**ADC Planning Consultation
Response from the Historic Buildings Adviser**

Application Number	P/105/14/PL
Address	Sefter Farm, Pagham
Description	Demolition of agricultural store and extension to agricultural building.
Case Officer	Simon Davis
Site Visit	26 November 2014

No Objection subject to amendment

PLAN 1:500

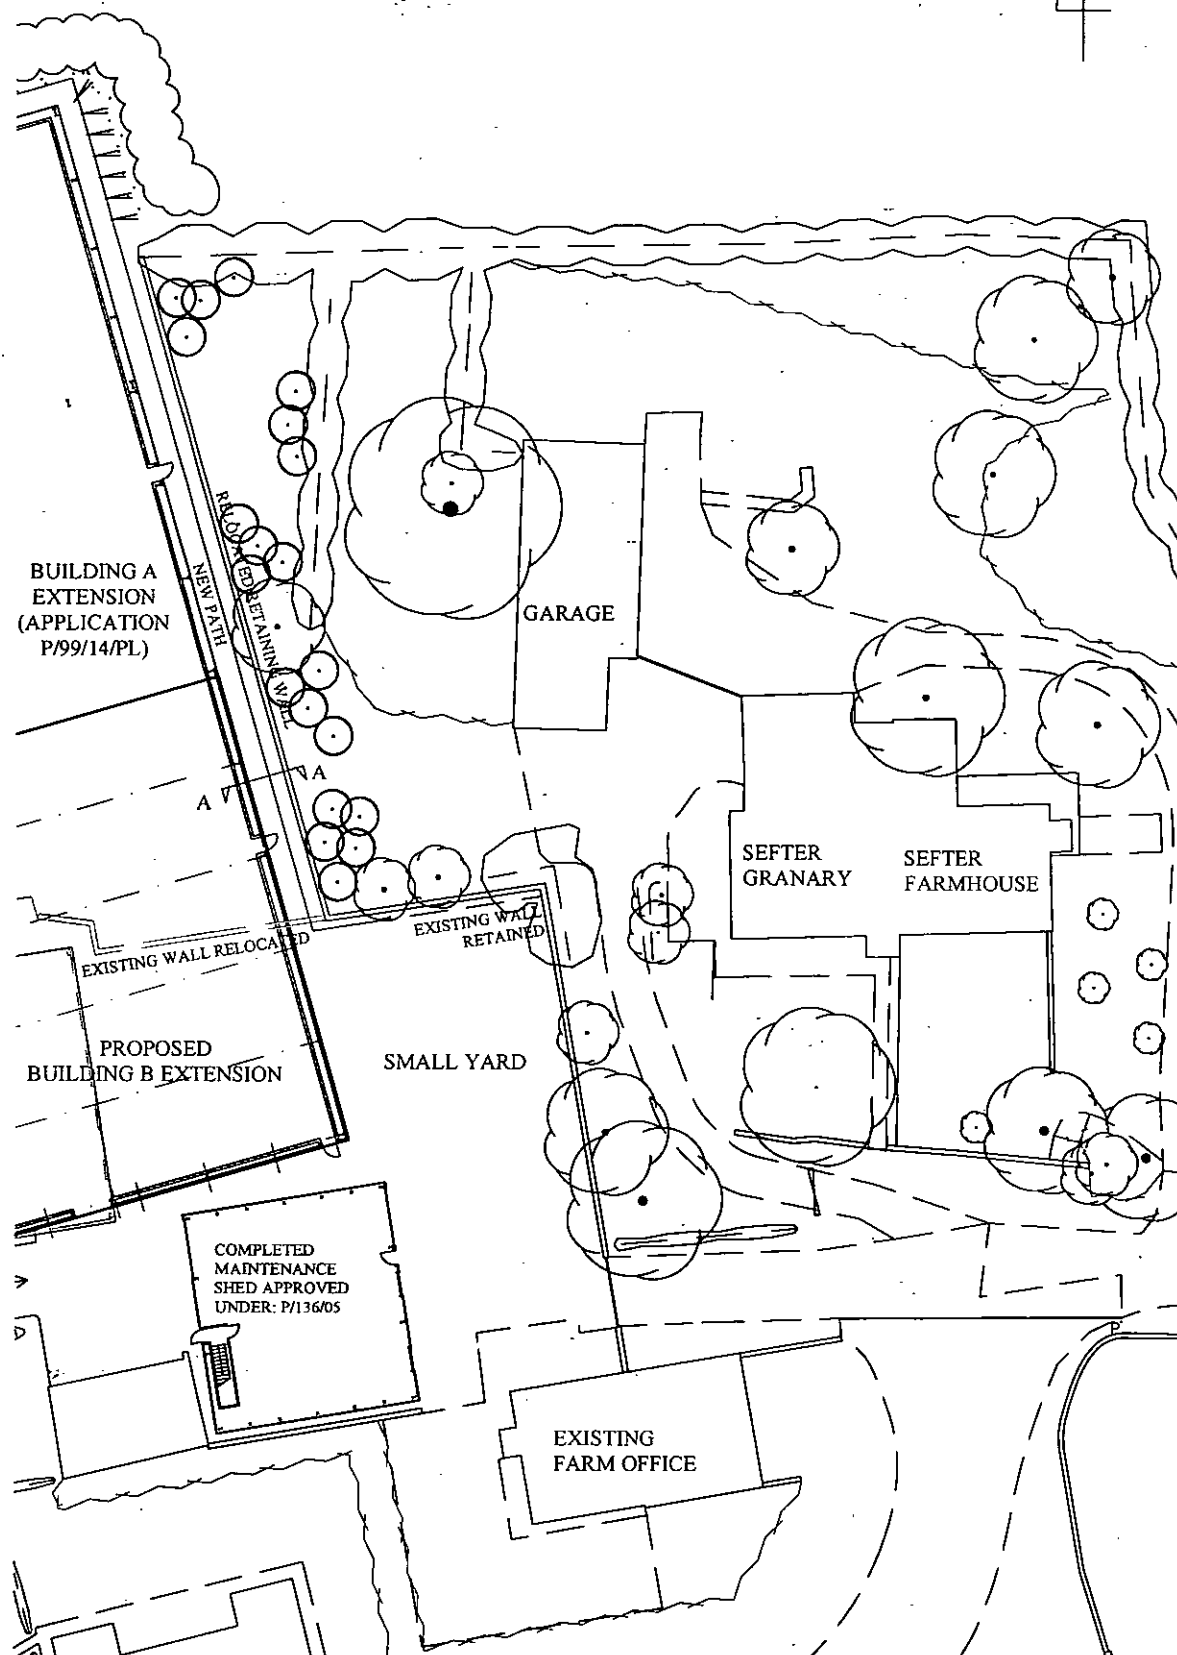
This scheme seeks to extend on application P/99/14/L by proposing a further larger addition to the south. The width of the proposed building is such that it results in a higher ridge level, but also appears to produce a structure of considerable bulk and massing. Seen in context with the listed building, it is likely to represent a level of harm to its appreciation and thus its setting.

Given these concerns, we would suggest a compromise in which the proposed building was reduced to approximately half its size to reduce

massing in the setting, but also avoid the loss of the wall and courtyard. A smaller building, or component of the extension could be maintained where the current building is located and would be approximately the same size. This would provide about 75% of the proposed floor area, though obviously less cubic volume. If this is not feasible then justification for the proposal should be considered in potentially broader terms in accordance with para 134 of the Framework.

Proposed
Relocated Retaining Wall Details
September 2014
6807b-104
1:500, 1:20@A3

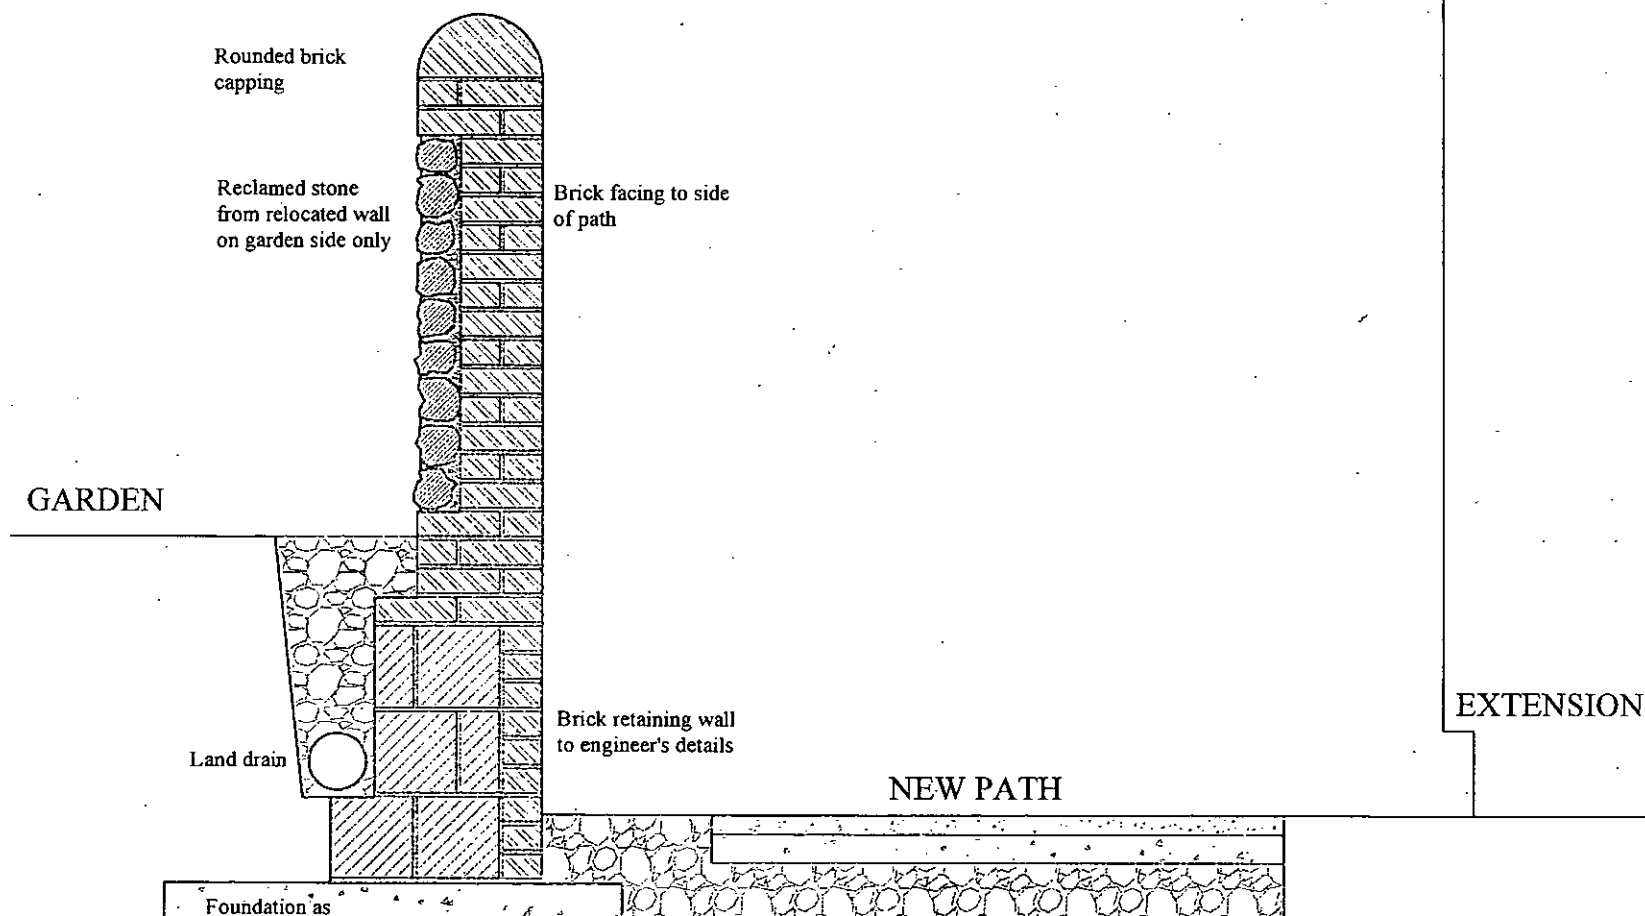
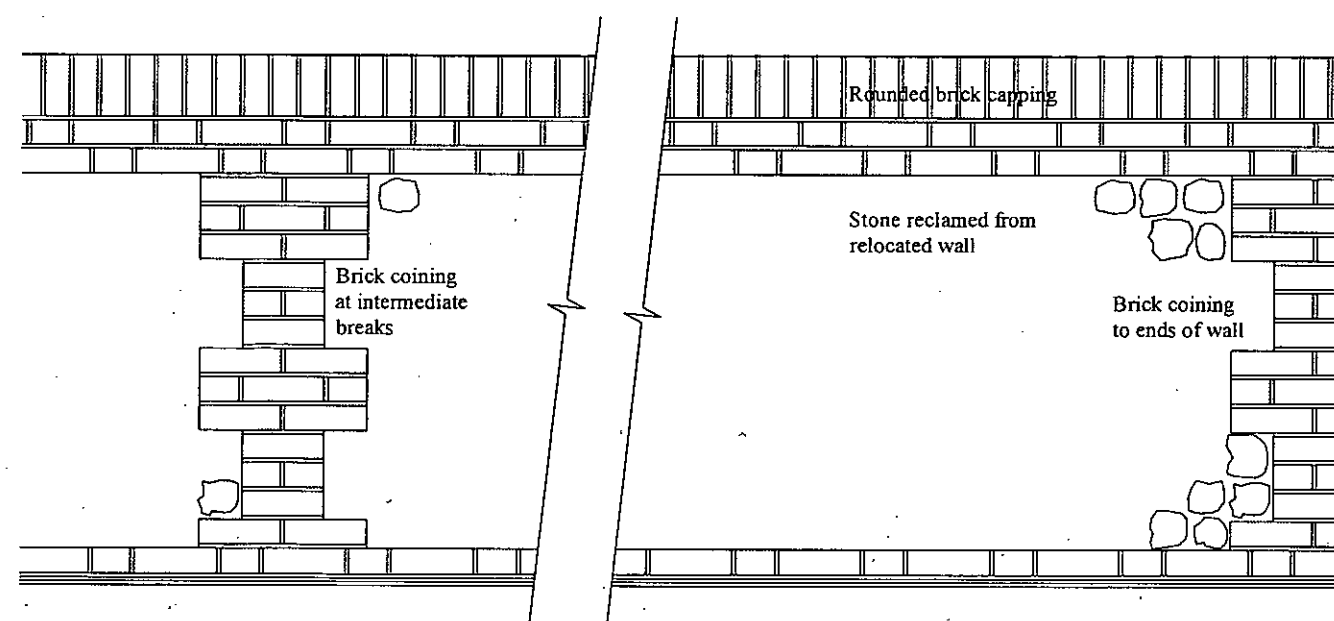
A more direct impact is the loss of a section of wall and encroachment into the historic farm yard which is evident on historic mapping. This wall is of interest as a farm boundary, as well as being made up of various materials including, flint, brick and what appears to be Bognor rock. Other areas of the wall have already been replaced by brick sections meaning that any surviving sections may be considered to be of greater value.

It should be noted that the value of setting is not reliant on public amenity or access, nor is screening by plants or trees recognized in historic environment terms, as an appropriate means of mitigation. Any impacts should be designed out wherever possible. Similarly, the loss of the historic wall is not ideal given its relationship to the heritage asset and contribution to the site more generally. The re-use of the materials elsewhere does little to mitigate this, though if this were to happen, repairs to the existing boundary would be perhaps more satisfactory than forming a stone boundary that did not formerly exist and might be misconstrued. The preservation of setting is sought under para 137 of the Framework.
